August 24, 2007

RE: 59 Myrtle Street – 026 K002 - R-6 – Proposed deck – permit #07-0996

59 Myrtle Street Plot Plan
 Adam Hill
 (207) 615-5267

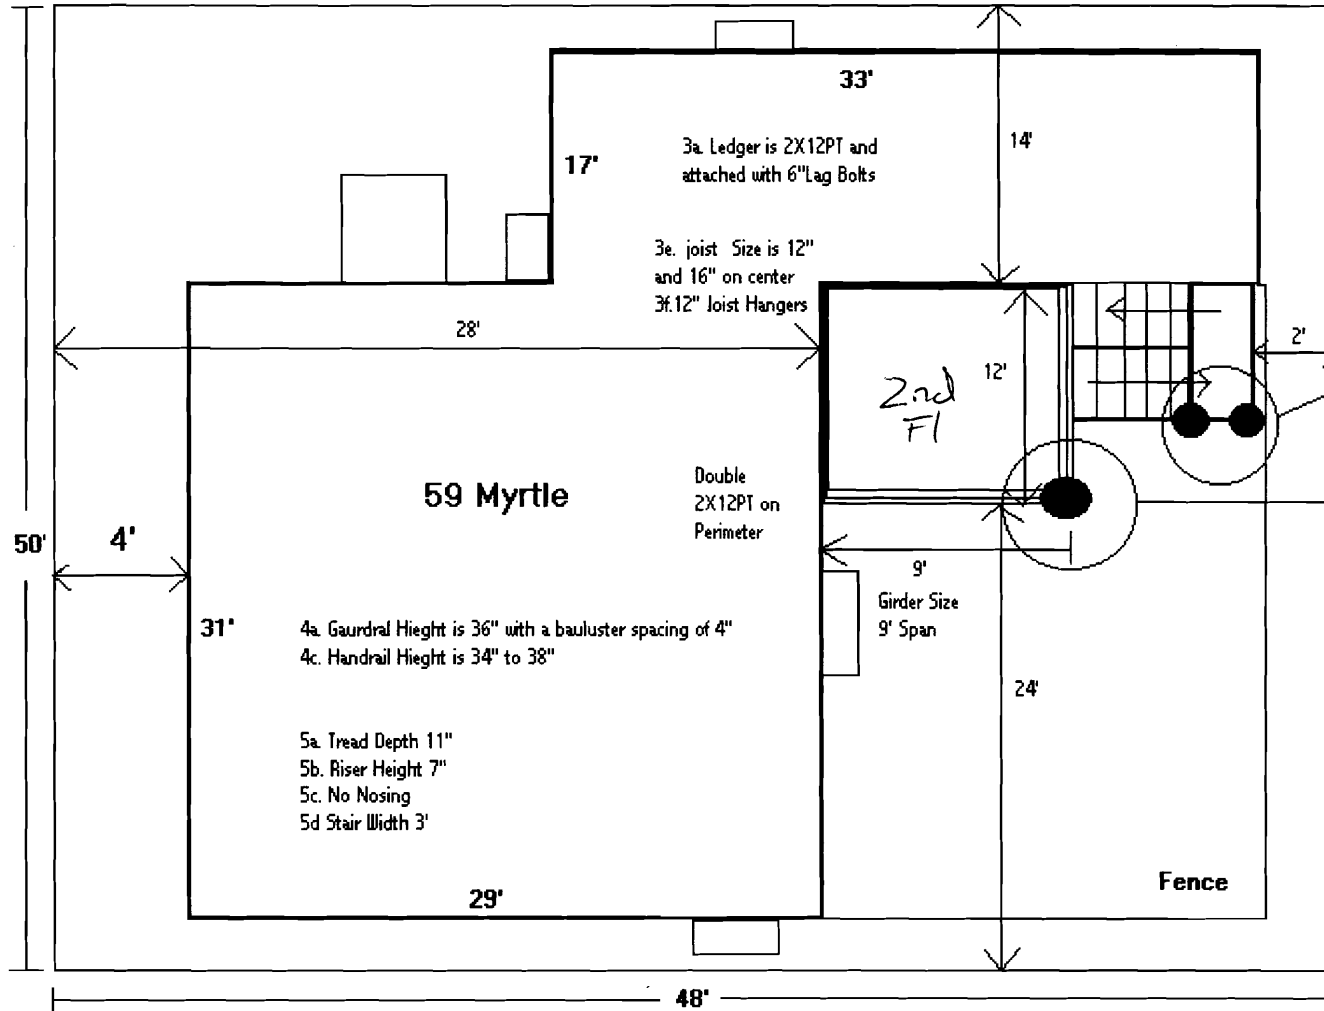
This letter is a follow up to the voicemail that I left you yesterday. You have an application to build a nine -foot by twelve foot second floor deck and stairs at your property at 59 Myrtle Street. Your property is located in the R-6 residential zone. Section 14-139(d)(3) of the land use ordinance states that the side setback in the R-6 zone is ten feet. Your site plan shows that the setback to the landing for the steps from the side property line is two feet. Section 14-139(e) says that the maximum lot coverage is fifty percent of the lot area. Your lot is 2,381 square feet. Fifty percent of that is 1,190.5 square feet. The footprint of the existing building is 1,460 square feet, which is already over the maximum allowable lot coverage. Since your proposed deck and stairs does not meet either the side setback requirement or the lot coverage requirement, I must deny your permit.
